Application: SSI 7485

I write regarding the proposed modification to M4-M5 Link, Mod 2 The Crescent overpass and changes to pedestrian infrastructure in North Annandale, Rozelle and Rozelle Bay Foreshore area.

Figure 4-2 Pedestrian and cyclist bridge infrastructure options

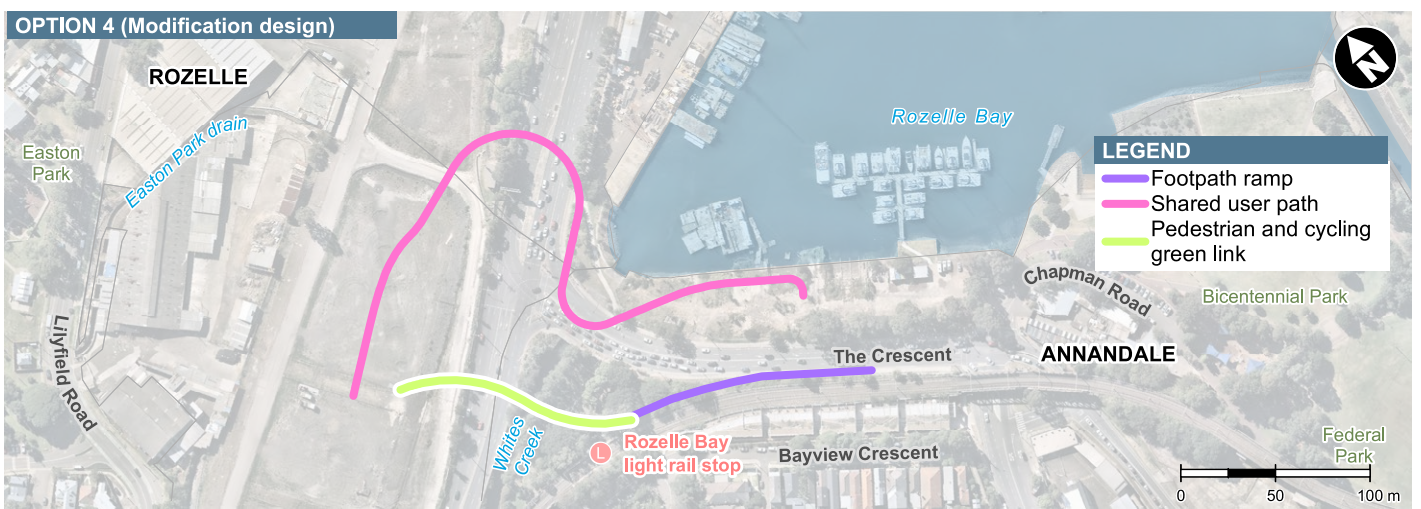
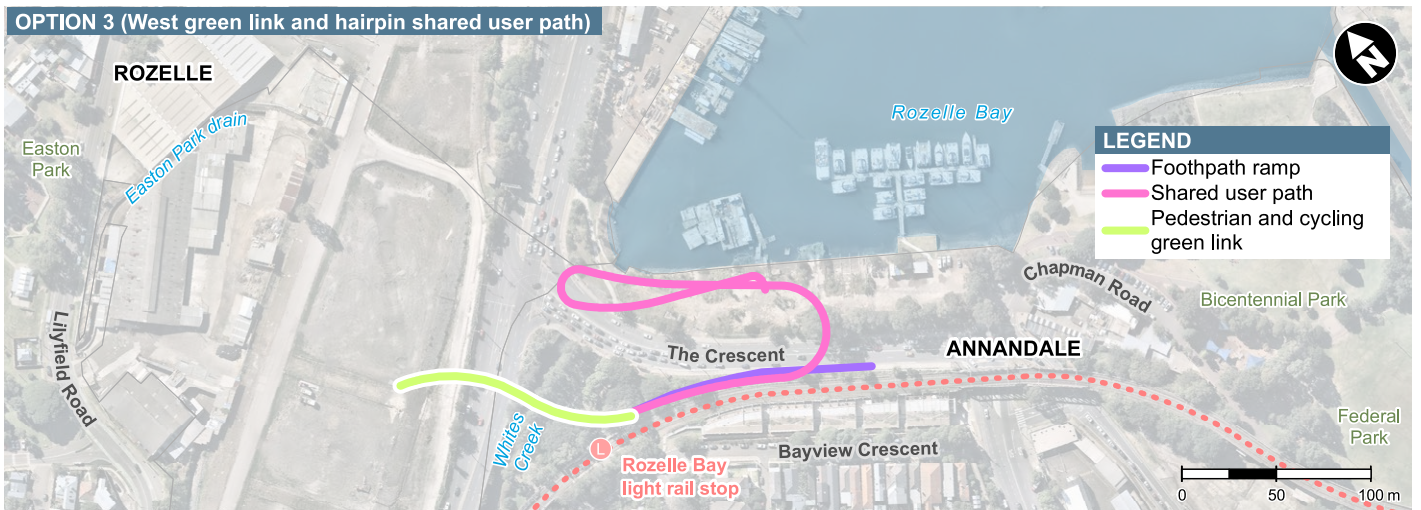
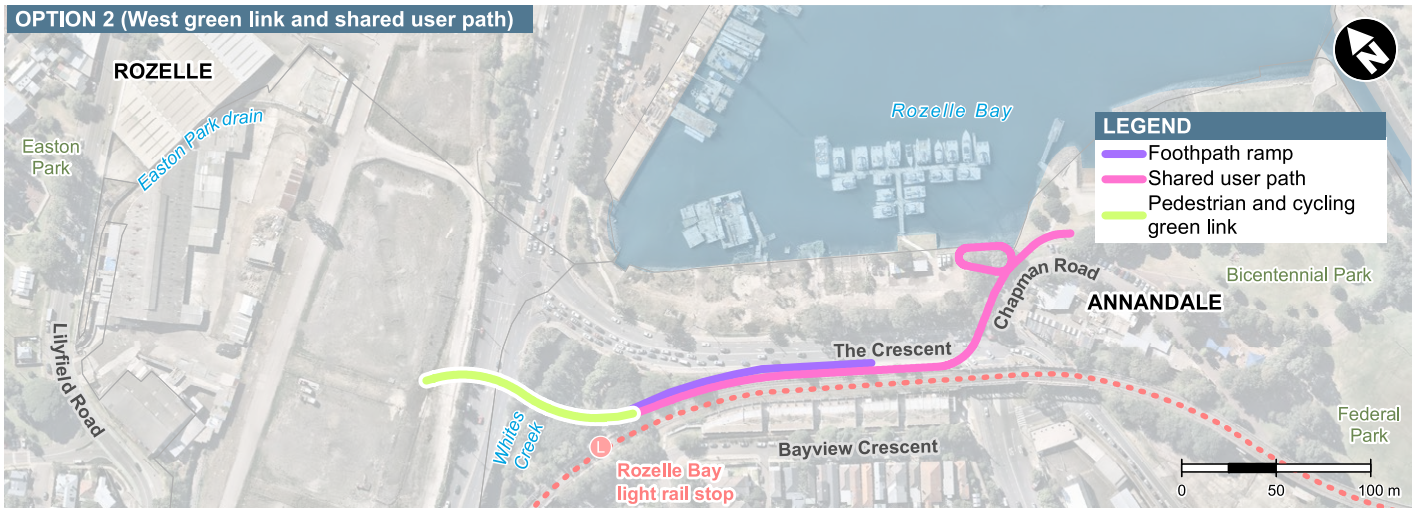
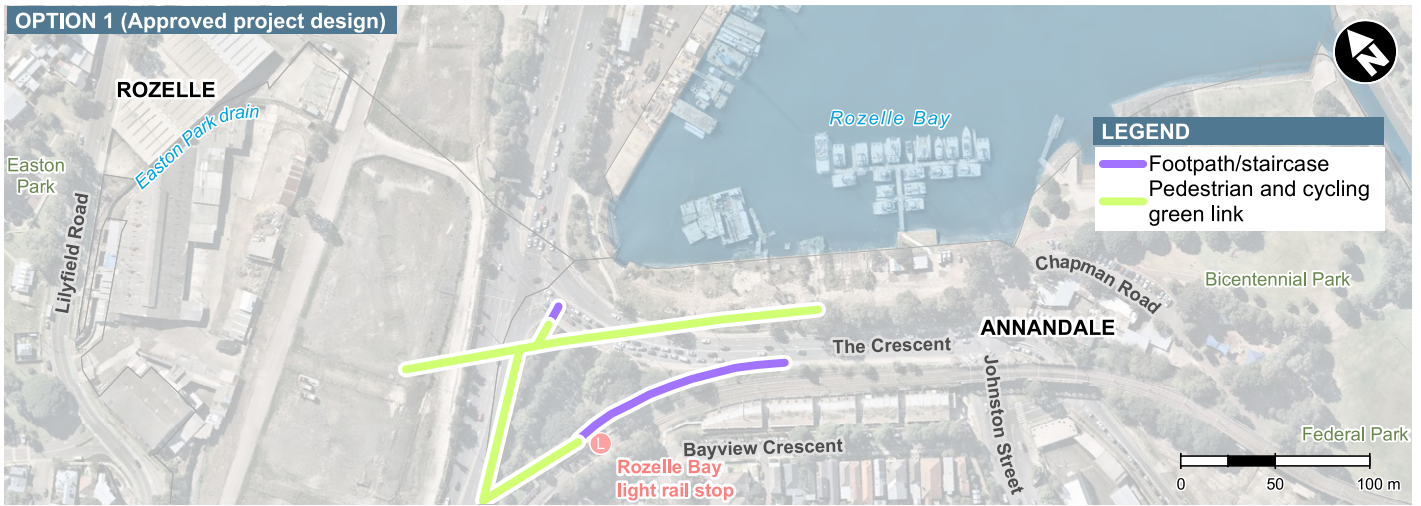
I request RMS work with the community to explore alternate design options to the proposed new car overpass design and the changed pedestrian and cyclist links. I am seeking the reinstatement of the safe, direct access from the approved EIS GreenLink to create a continuous green open space connection from the Rozelle Rail yards and Annandale to the foreshore. The GreenLink was more than just a walk way - it put people central to the design, maximising safety, and providing much needed accessible open space for the community now and into the future Bays Precinct design.

- The significantly reduced safety and increased risk for pedestrians and cyclists with removed access over The Crescent to Bicentennial Park and the increased traffic along Johnson Street.
- Being required to cross five sets of pedestrian lights at The Crescent as my option to reach the foreshore from Annandale or from Rozelle Bay light rail stop.
- Removal of direct active links to the foreshore, cutting the community off from the area and the proposed revitalisation of the entire Bays Precinct, including linking the Light Rail and Bus stops to a Ferry wharf and Metro station.
- Urban and landscape design that is being built before a finalised Masterplan for the area.
- Traffic changes that limit movements around the suburb and create further congestion in the local streets of Annandale, Forest Lodge, Glebe, Lilyfield and Rozelle with no planning to deal with these.

- Reinstate the GreenLink connecting communities and green open space from Rozelle to Bicentennial Park
- Relocate and design pedestrian and cyclist connections that are continuous, safe and direct.
- Design the modification infrastructure and active links in response to the character of the suburbs, the location of the foreshore and it's potential future development.
- Provide pedestrian and cyclist paths that maximise people safety and do not force them onto busier streets, unsafe concrete plazas and caged walkways.
- Integrate active and direct connections to all active transport – including the future Metro West and Foreshore Ferry Wharf

Figure 4-4 Elevation: Indicative view of The Crescent overpass

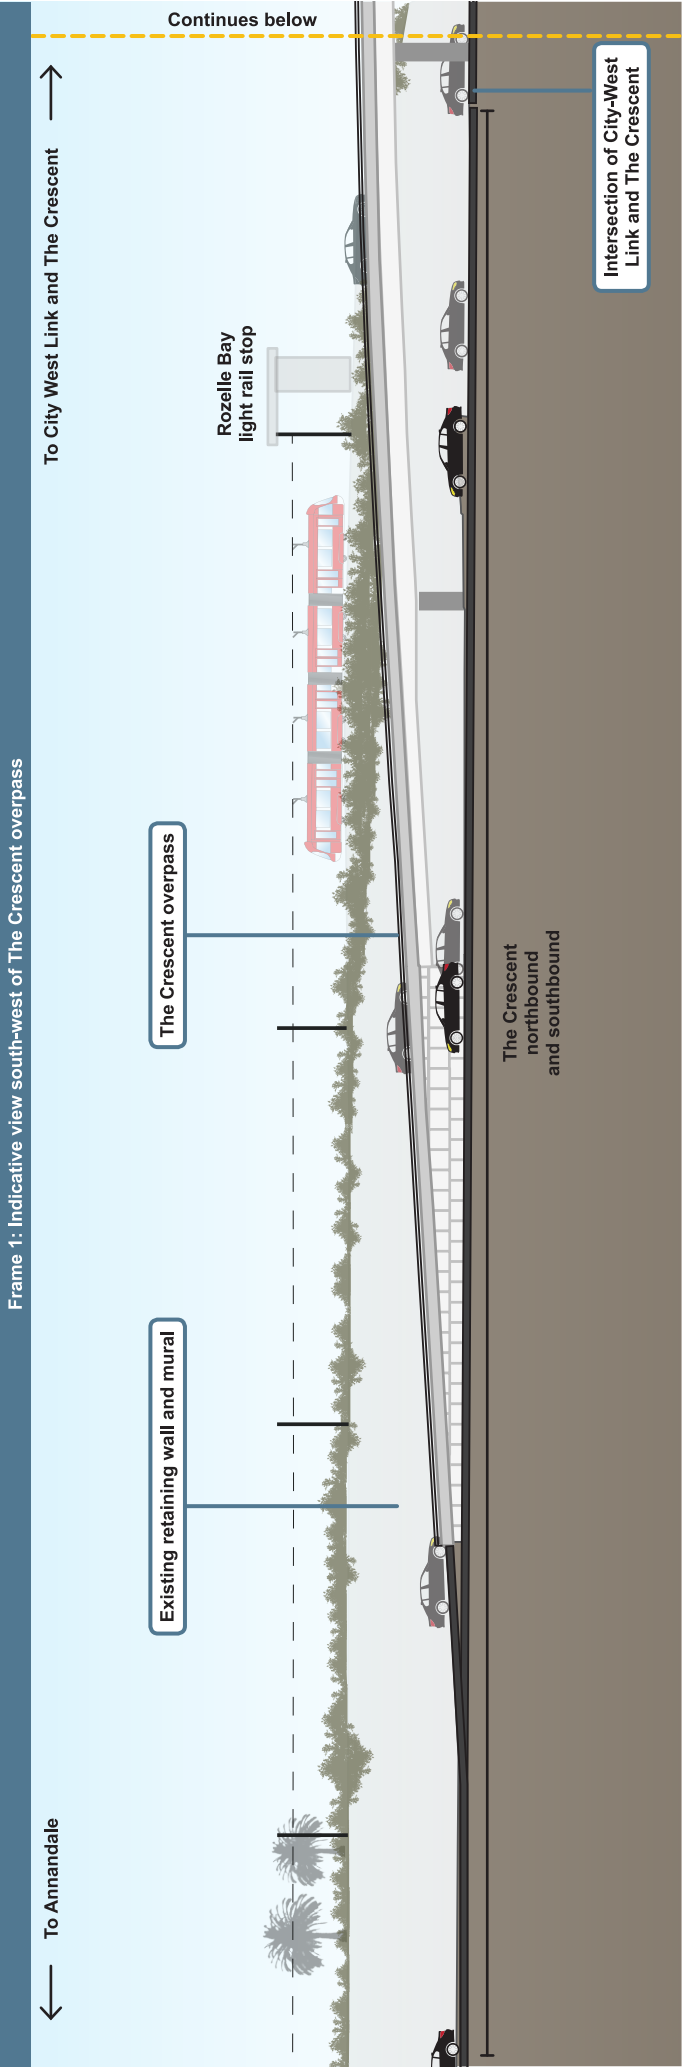
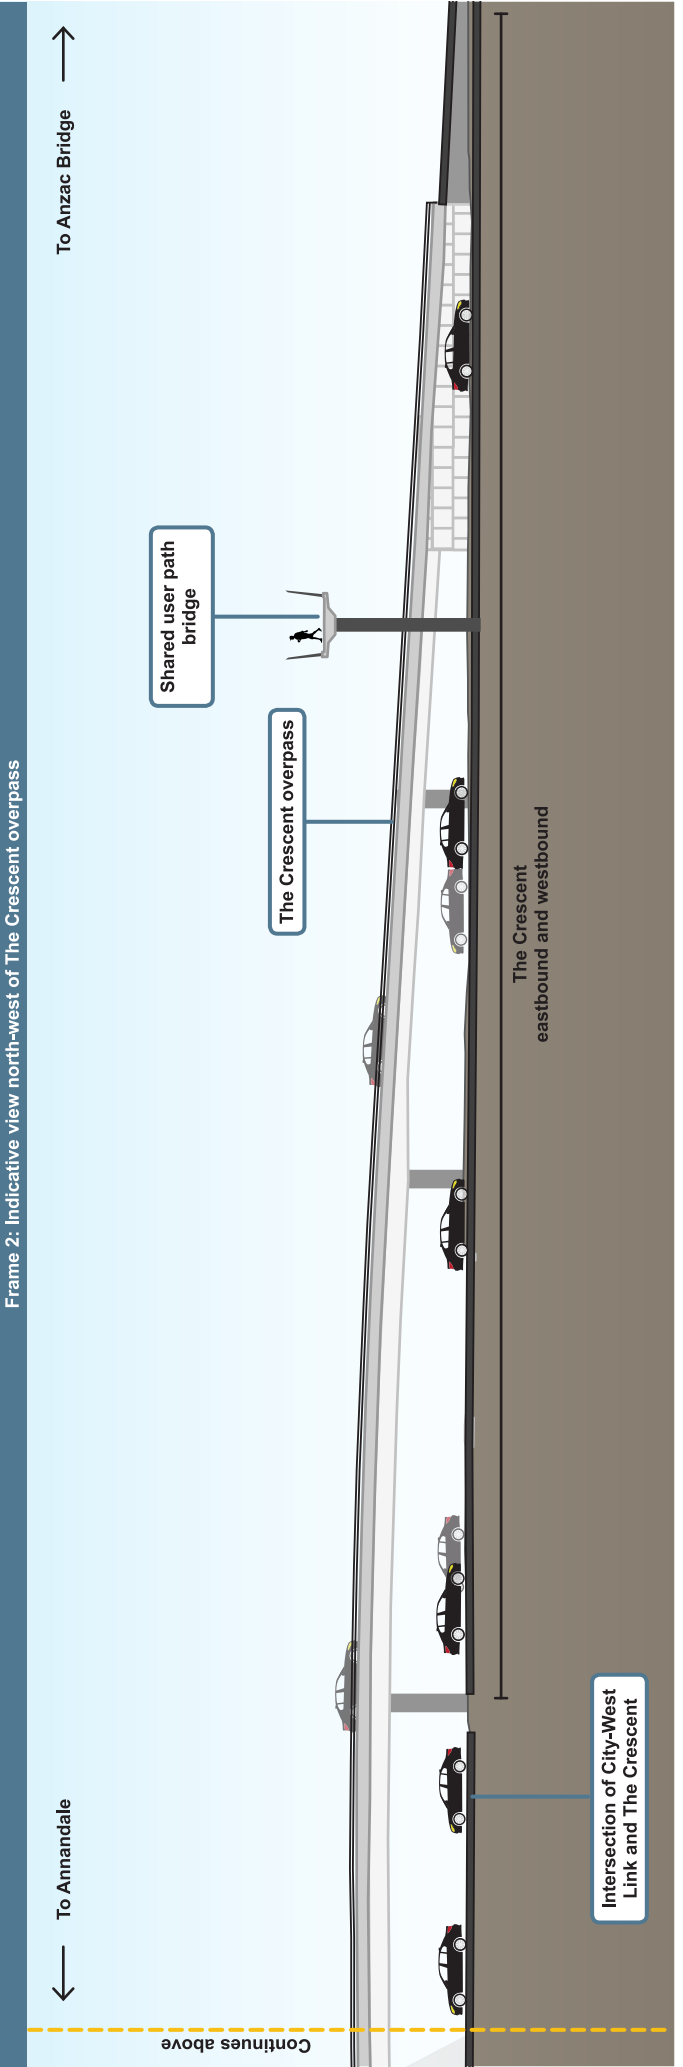
I am requesting RMS put people back into the plan - we want you to reinstate your own vision as laid out in Transport for NSW Future Strategy 2056. Work with us to design a feasible option that brings the best elements from the approved EIS design into the modification.
